110 O'Connor Street | Informal Pre-consultation | Site Plan Control Application | Groupe Mach, Geiger Huot Architectes, Fotenn Planning + Design

Key Recommendations

SECTION ELEVATION: REAR OUTDOOR AMENITY AREA 'AT-GRADE' VIEWING EAST

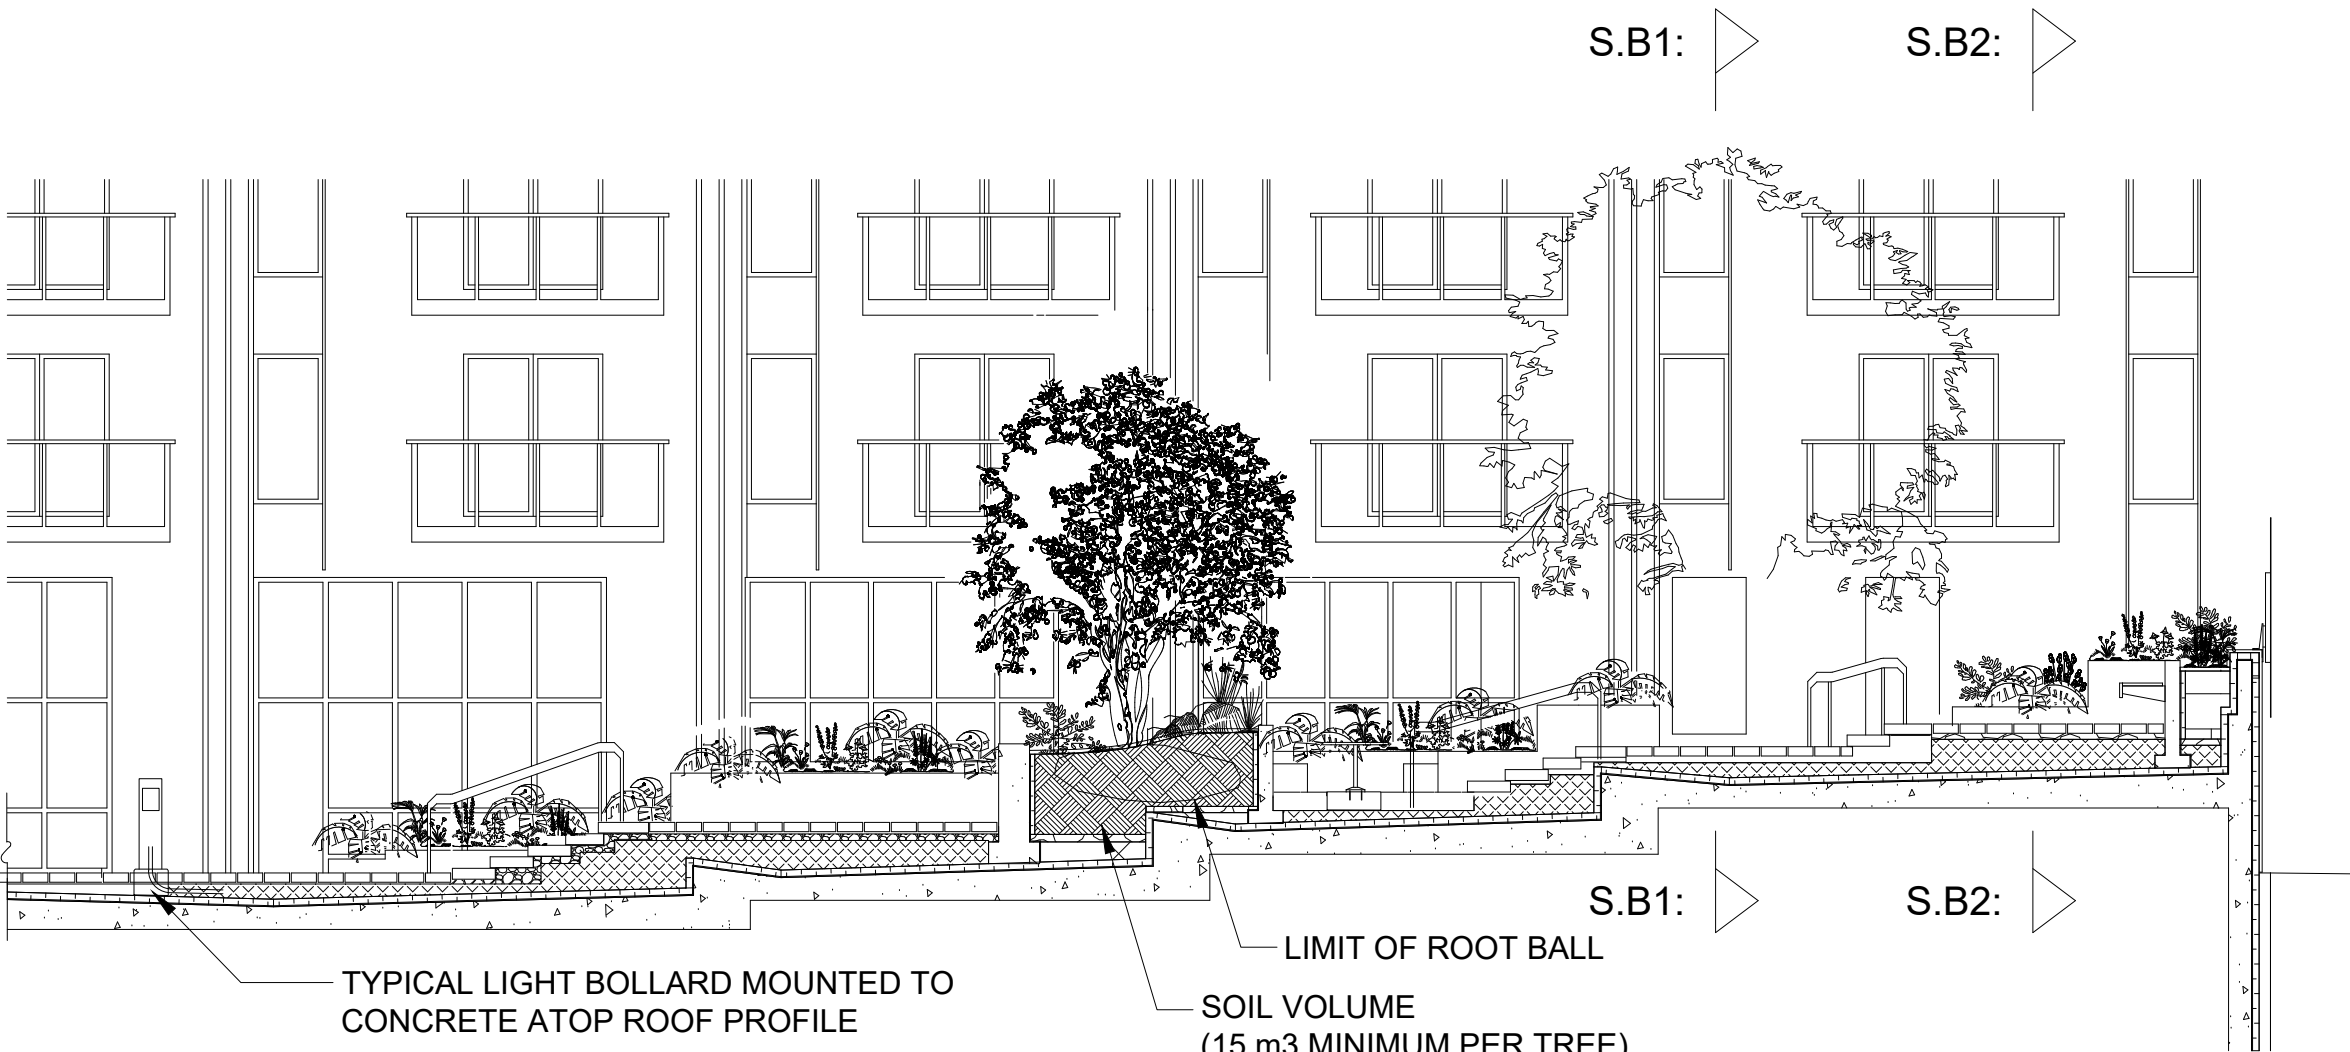
- The Panel cautions that the proposed exterior amenity at the rear of the building is located next to the garbage room and will be quite a dark and pinched space with adjacent buildings. It is unlikely the exterior amenity is going to be used as it has been rendered, and more likely will be used as a dog run. Consider rethinking how that amenity space will be used, given how dark it will be most times of day.
